**Reduction to the maximum number of students and
amendments to the internal layout and awning at
Cleveland and Abercrombie Street
157 – 163 Cleveland Street, Redfern
SSD-4949-2011 MOD 4**

Director General's
Environmental Assessment Report
Section 96(1A) of the
Environmental Planning and Assessment Act, 1979

August 2013

1 Key Plan - Ground Floor
A02.101 1:200

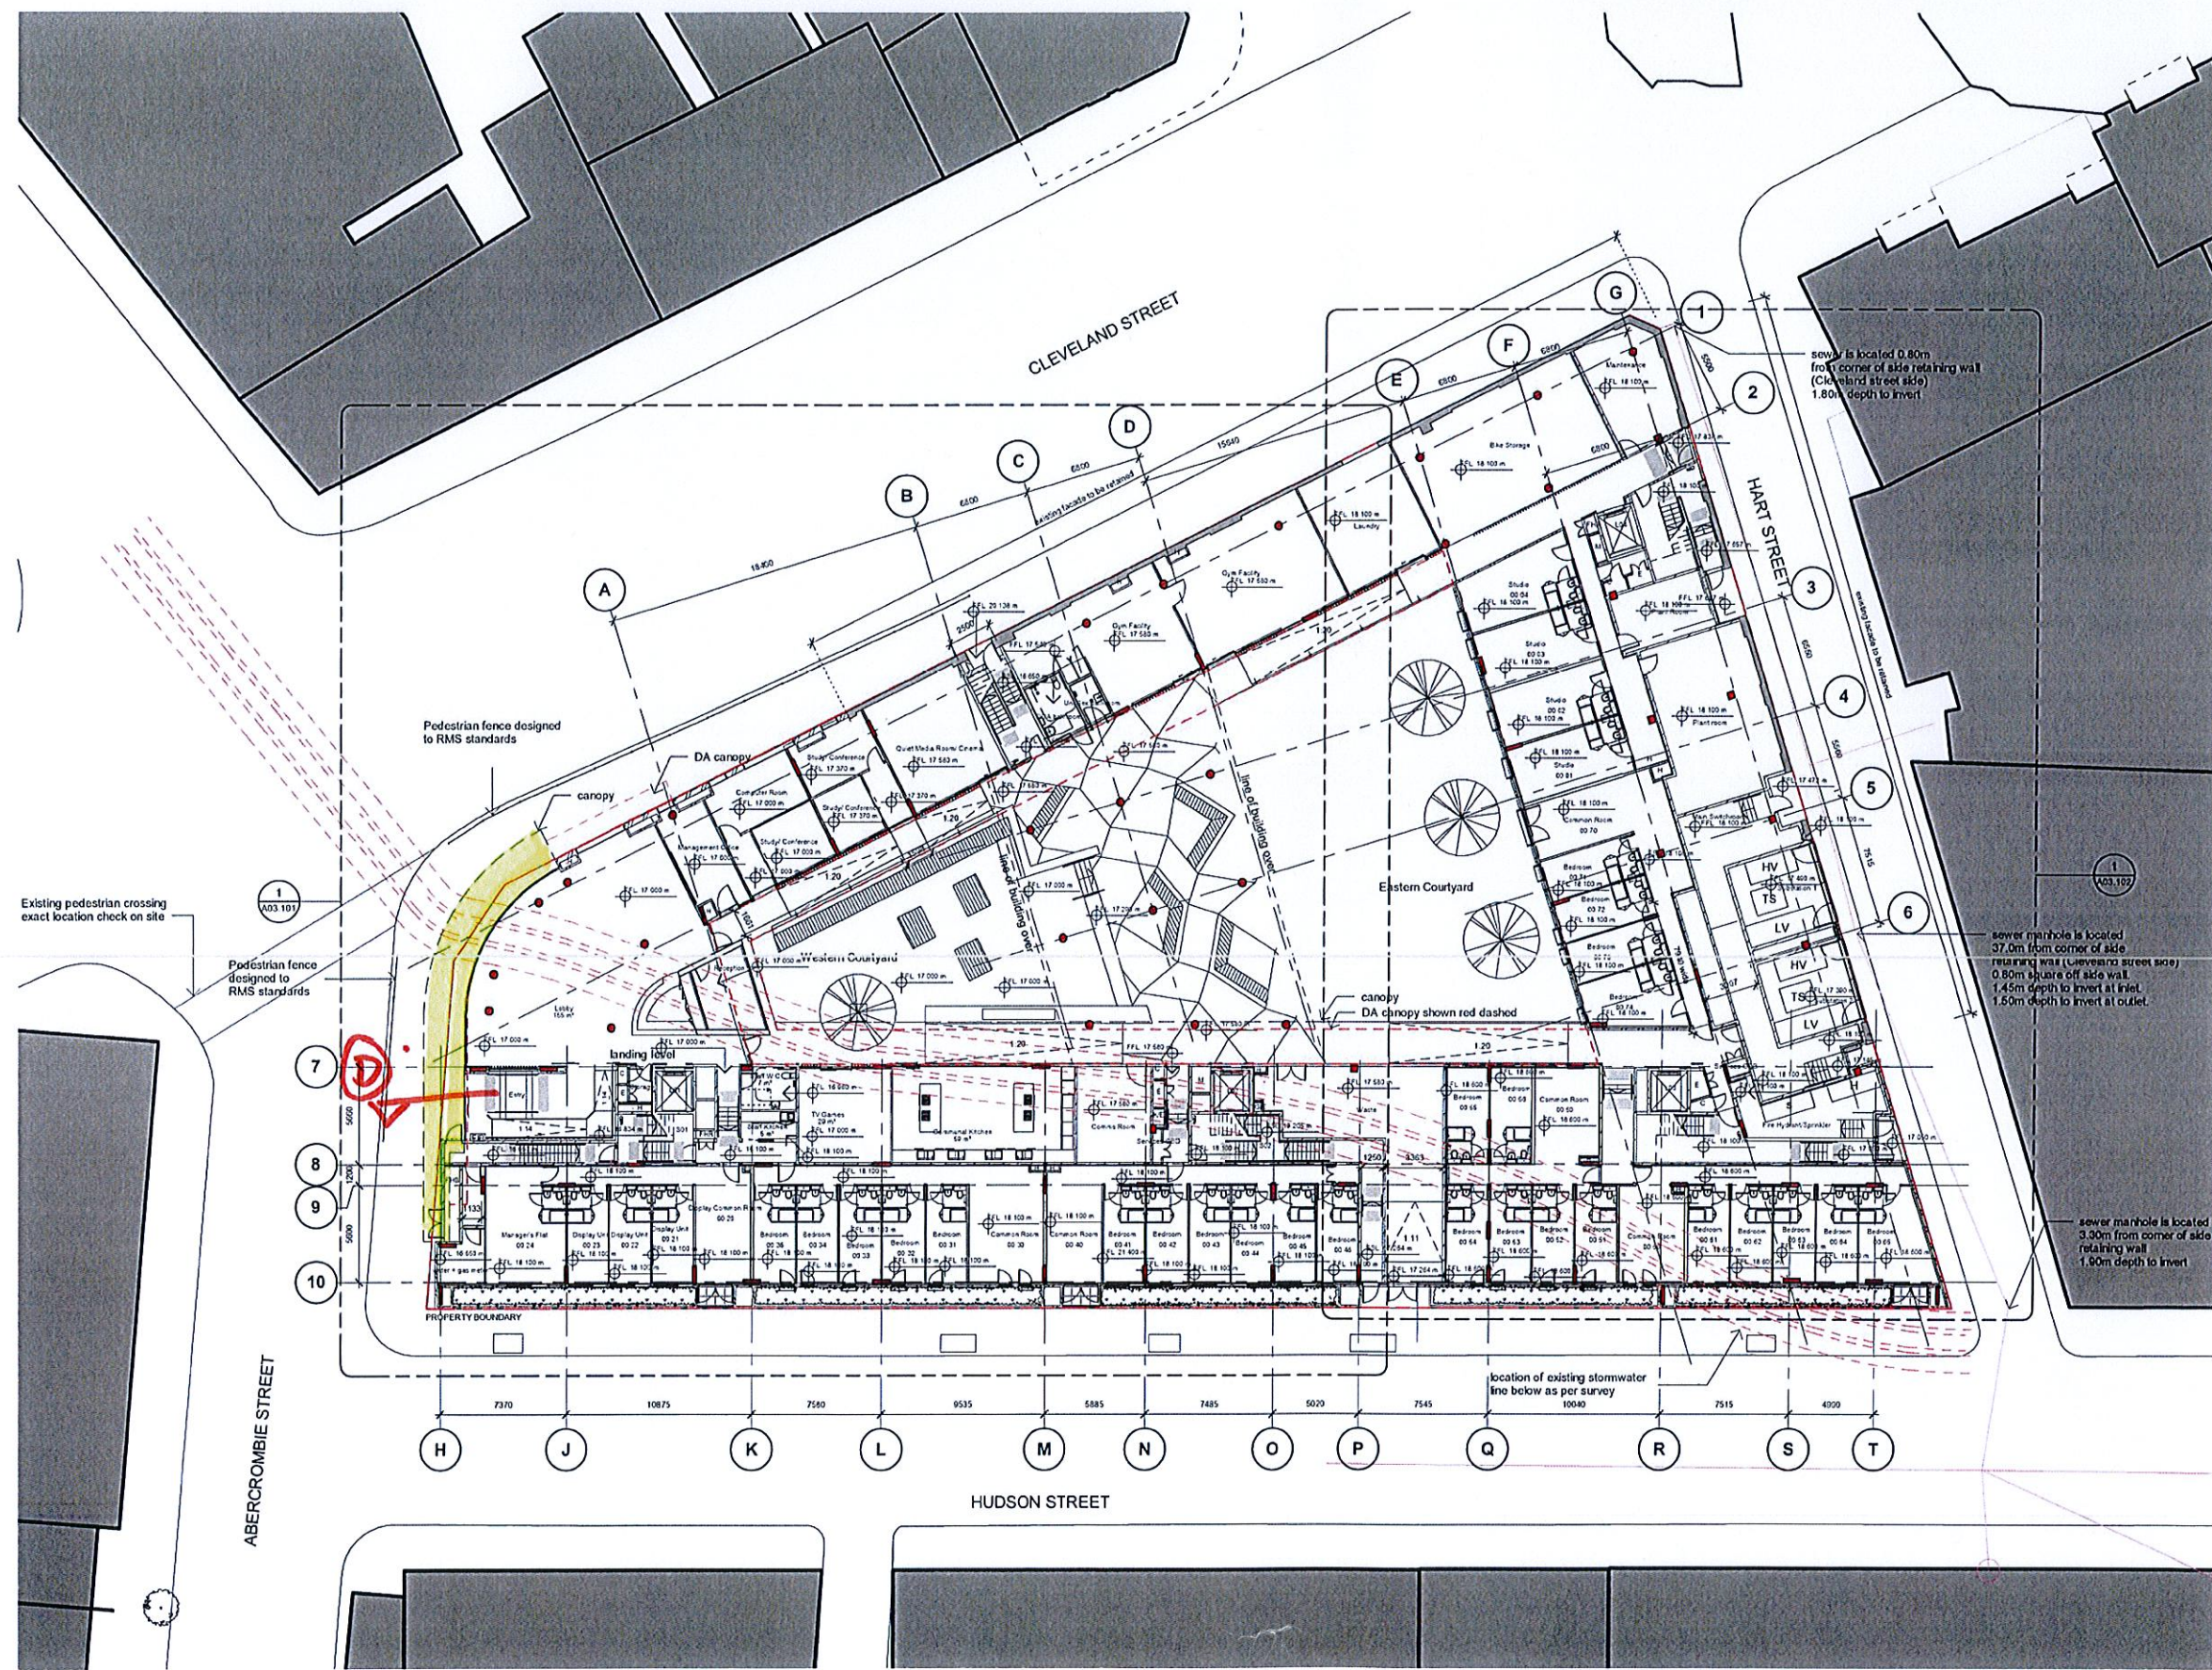
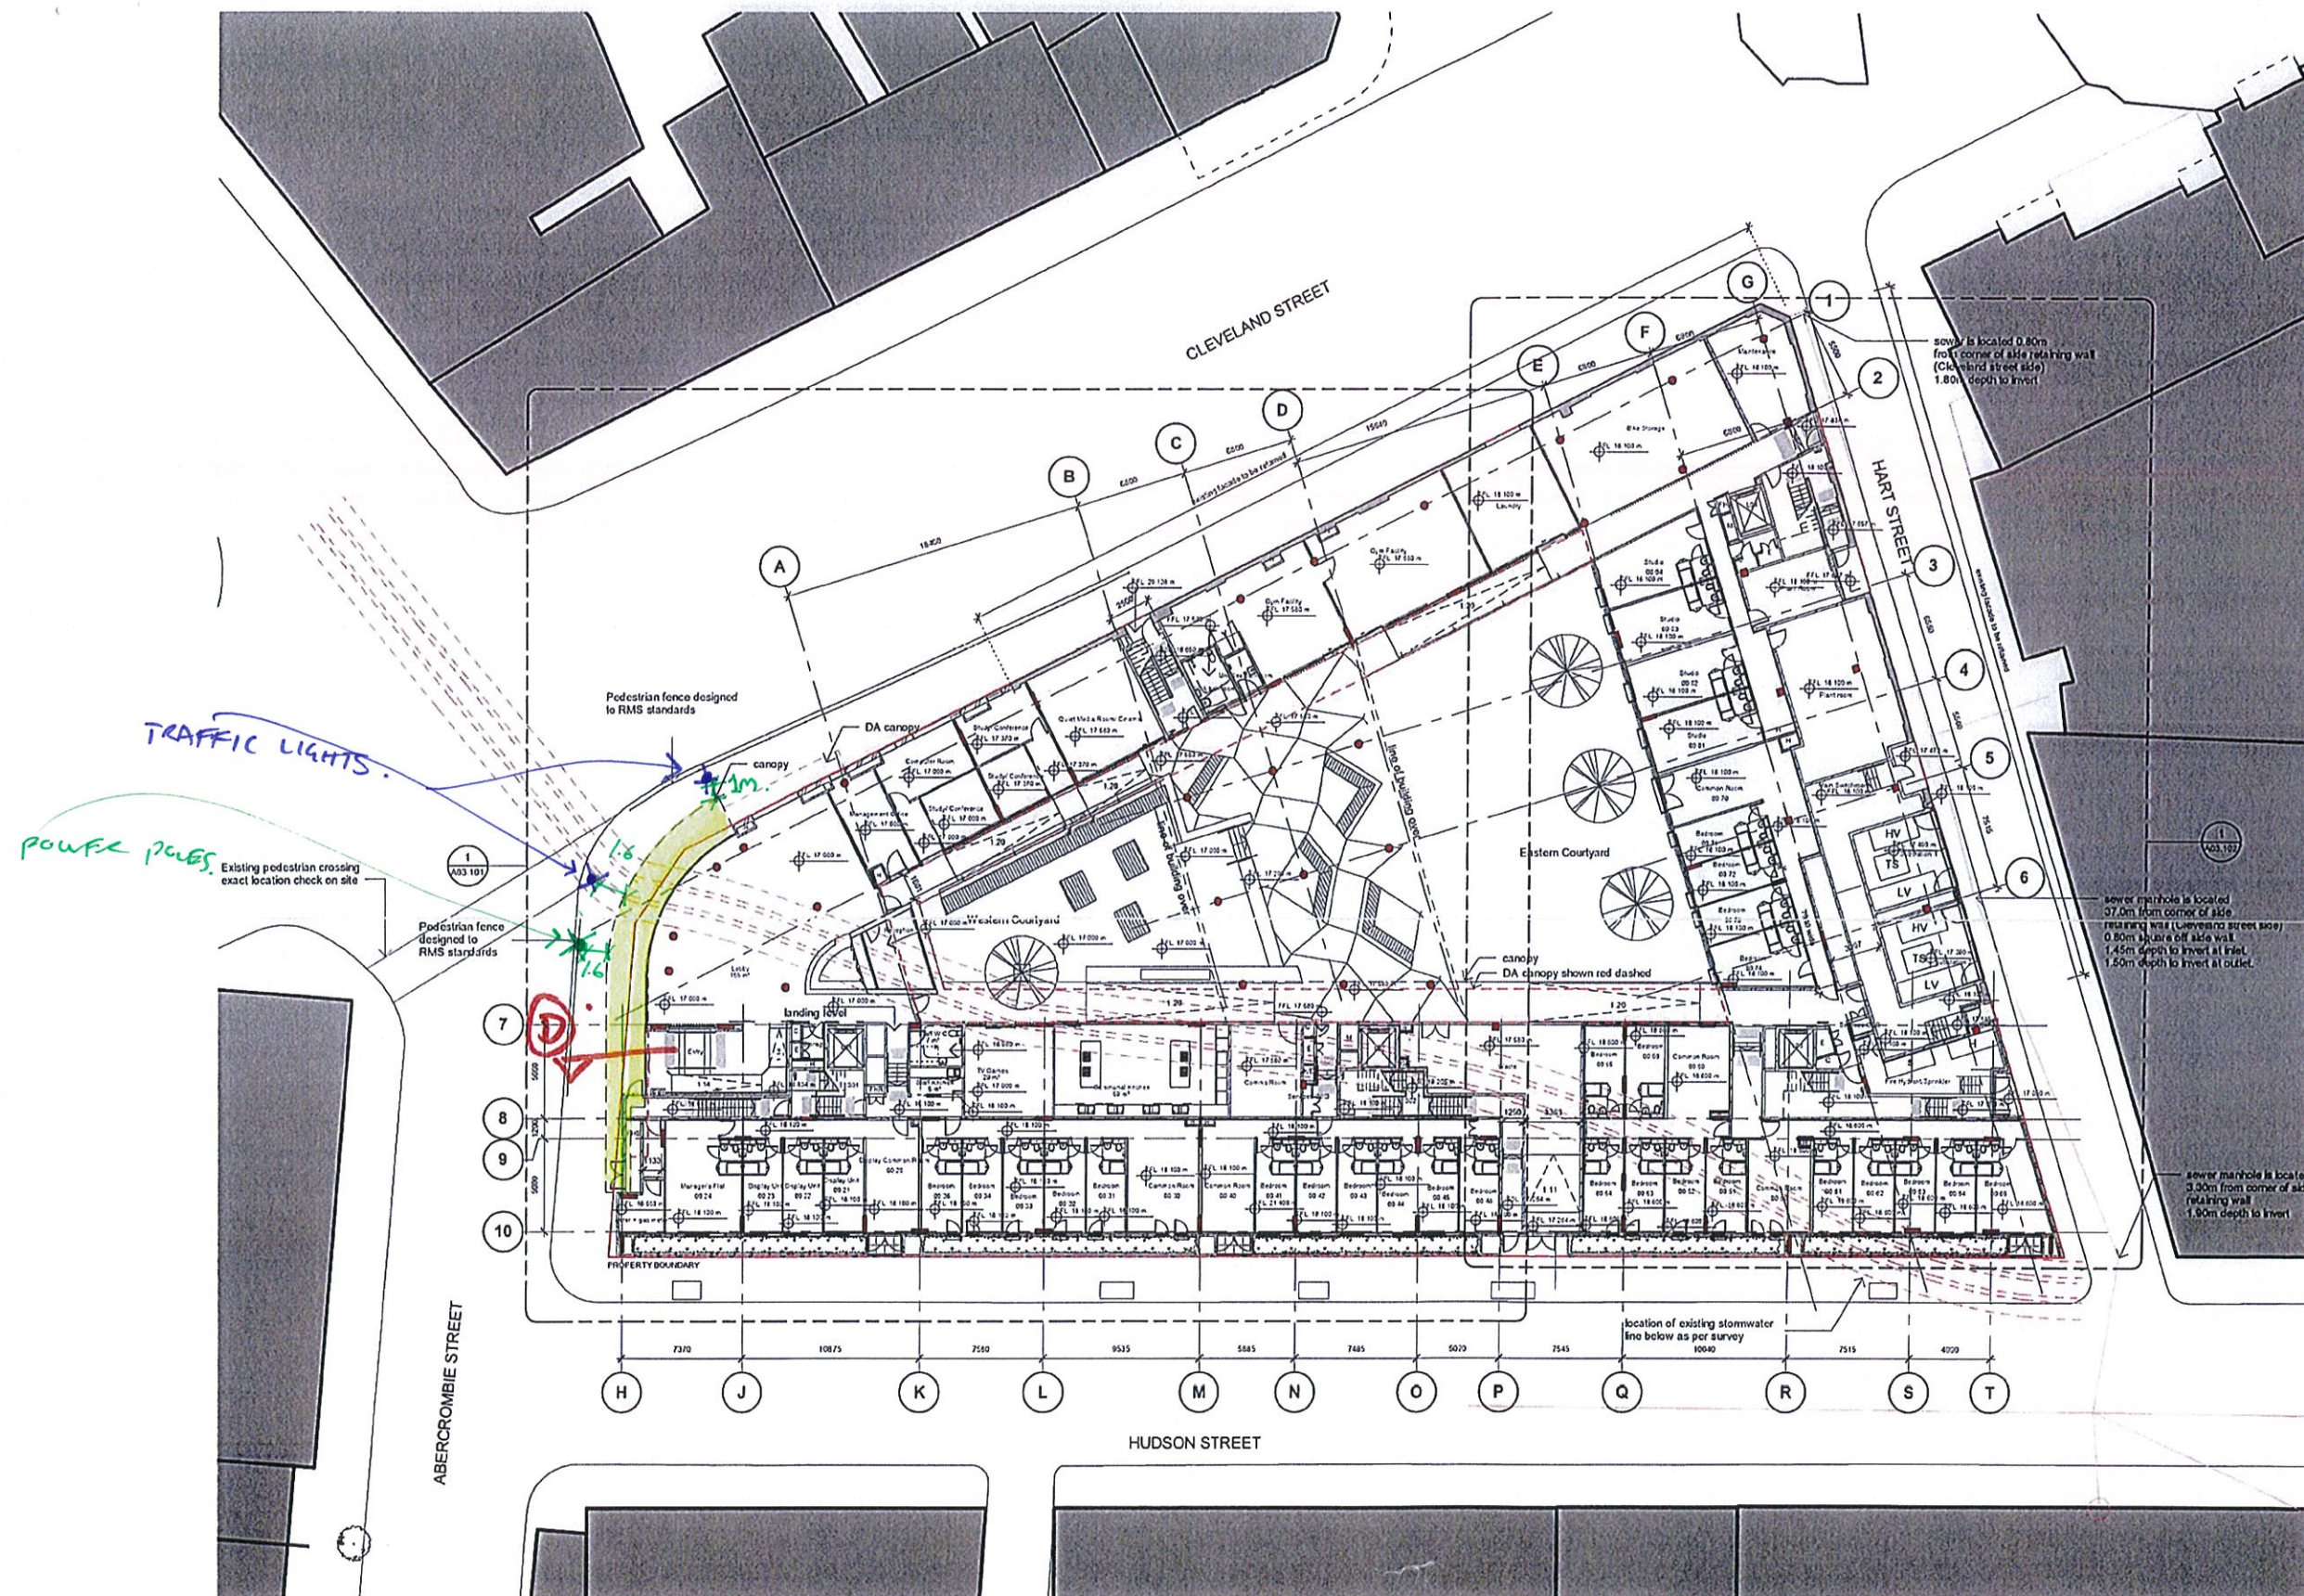
It is noted that Council have commented that it is unable to assess the potential impacts of the proposed awning on street trees, power poles, traffic lights and have requested the Department give consideration to minimum setback requirements from the kerb for any new awning in accordance with Sydney Development Control Plan 2012.

The Proponent has subsequently submitted additional information demonstrating the proposed awning complies with the minimum setback of 1 metre from the face of the kerb to accommodate smart poles, utility poles and vehicles in accordance with Sydney Development Control Plan 2012 (**Figure 5**).

The Department has included the condition accordingly in the recommended instrument of approval.
